The Sizewell C Project

5.6 Sizewell Link Road Flood Risk Assessment Addendum

July 2021

DRAWING TITLE:
 ENVIRONMENT AGENCY
 FLOOD ZONE MAP

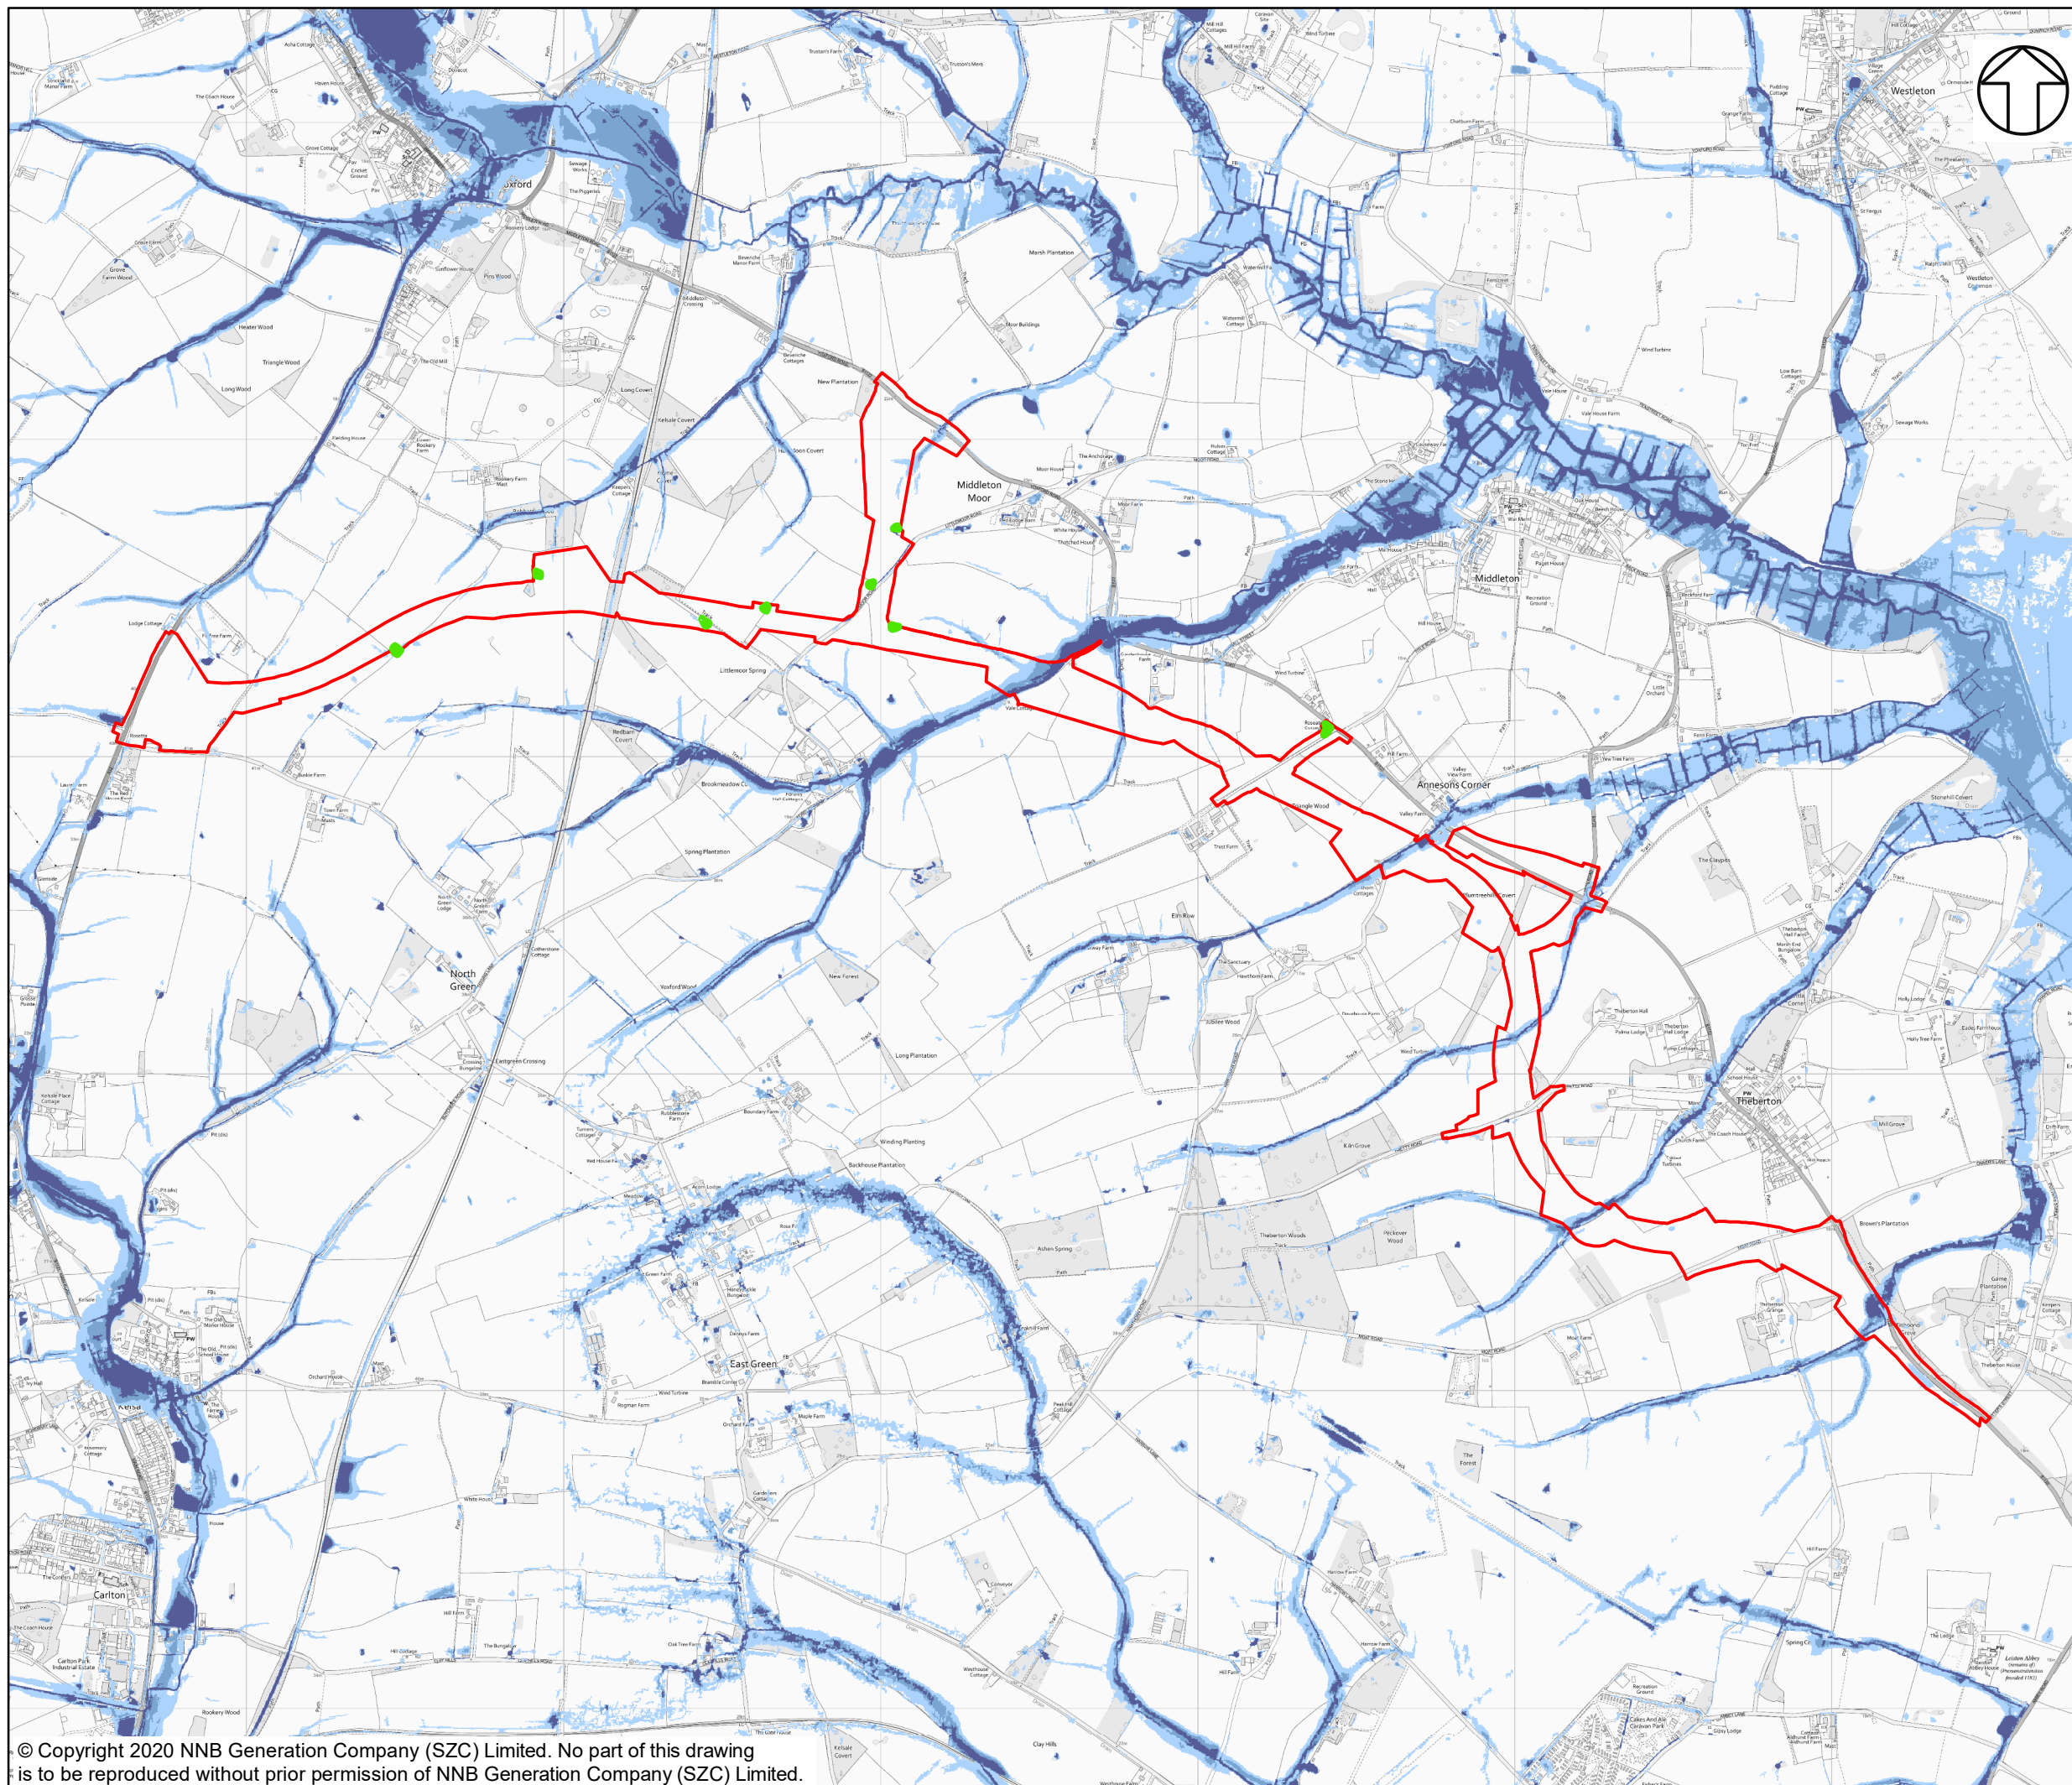
“FRA states & concludes that the SLR site is in Flood Zone 1 which has not been proven in the FRA. [...] FRA concludes the proposed development takes the sequential approach based on existing flood zones which do not map the flood risk from the watercourses in question.”

2.2.3 In the **Sizewell Link Road Flood Risk Assessment** (Doc Ref. 5.6) [[APP-136](#)], the Environment Agency's Flood Map for Planning (Ref. 2) was used to determine the level of risk at the proposed development site, although it was acknowledged that detailed modelling may not have been carried out for the derivation of the Flood Map to properly delineate these fluvial flood zones around the upper end of the catchments where the crossings are proposed.

2.2.5 Following the Application submission, further work has been carried out to revise and expand the assessment of flood risk for the proposed Sizewell link road in order to address the comments and satisfy the Environment Agency and other key stakeholders that appropriate consideration of flood risk has been included in the design process of each of the crossings. Details and outcomes of the additional assessment are discussed in the following sections.
